Application for Removal or Variation of a Condition following Grant of Planning Permission or Listed Building Consent

Number	
Suffix	
Property Name	Three Chestnuts
Address Line 1	Fen Road
Address Line 2	Holbeach
Address Line 3	Lincolnshire
Town/city	Spalding
Postcode	PE12 8QD

Change of use of children's care home (Use Class C2 Residential Institutions) to an independent school - Learning and Non-Residential Institution (Use Class F1 (A) Provision of Education)

H09-1133-23

PROPOSED SITE PLAN
Scale 1:250

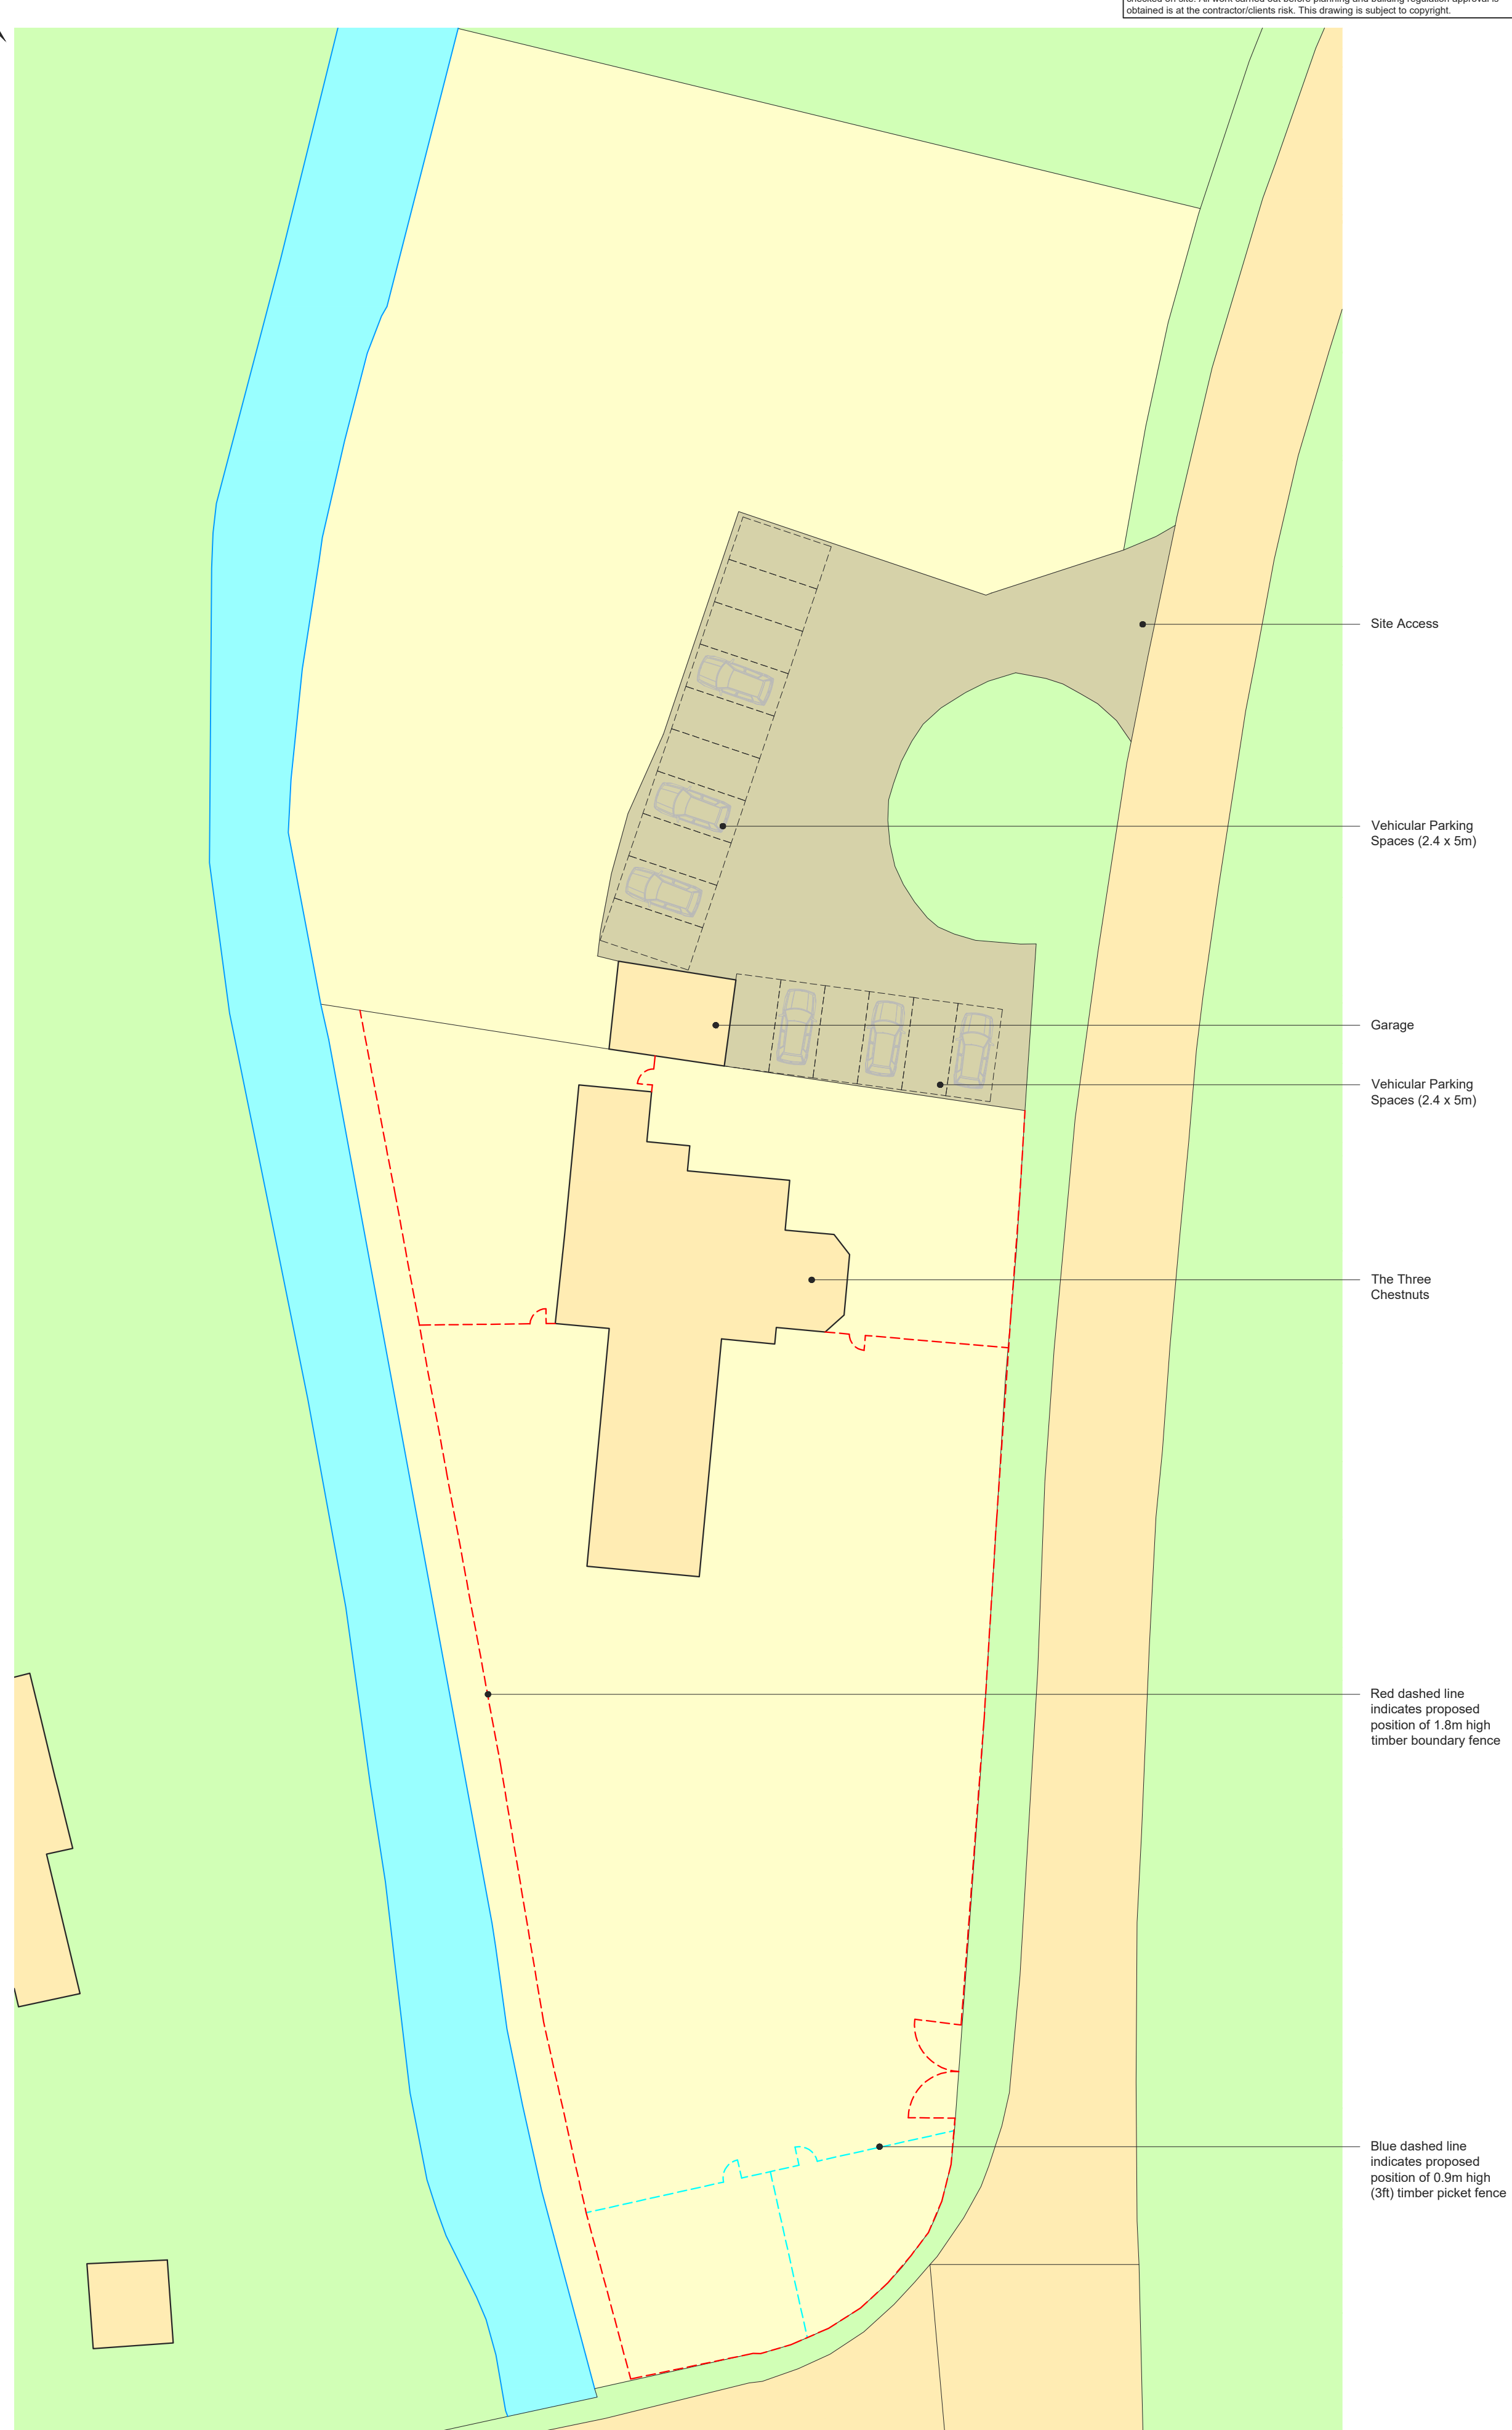
Drawing No.2312-04 to be substituted and replaced with 2312-04A (Proposed site plan vehicular parking spaces updated)

On site parking increased from 9no. vehicular parking bays to 16no. vehicular parking bays (Planning statement V1.1 and Drawing No.2312-04A)
